Our Ref: 24/00607/HFUL
Your Ref: 88 Station Road Histon CB249L...

South Cambridgeshire District Council Application for Planning Permission

Proposal: Retention of the raising of chimney A to the required 1.8m height above the new ridge.

Site address: 88 And 92 Station Road Histon Cambridgeshire CB24 9LF

SIDE ELEVATION (1:50 SCALE) SHOWING NEW HEIGHT OF  
CHIMNEY BRICKWORK (SAME POT) IN LIKE FOR LIKE  
BRICKS + MORTAR TO ACHIEVE REQUIRED 1.8m TOP OF  
POT TO THATCH. NO OTHER DIMENSIONS ALTERED.

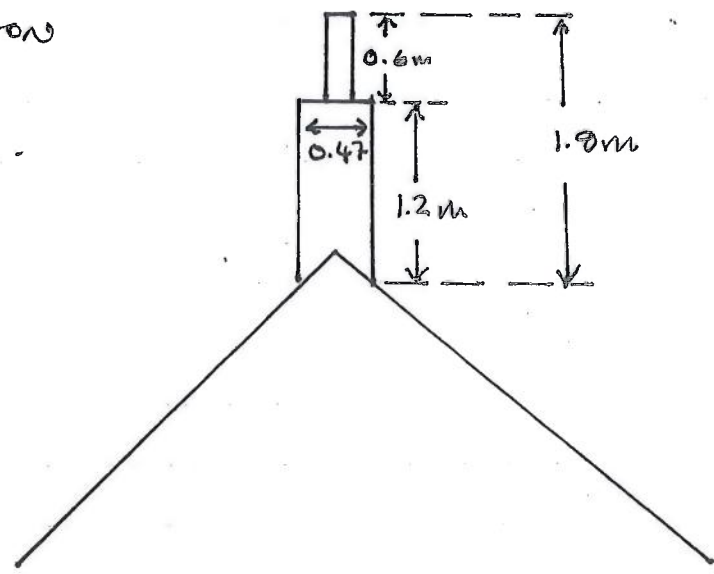
2. Please provide a drawing showing the side elevation of the chimney so that we are able to ascertain the depth. This plan must be drawn to scale.
3. Please confirm in writing whether you agree with the above amended description.
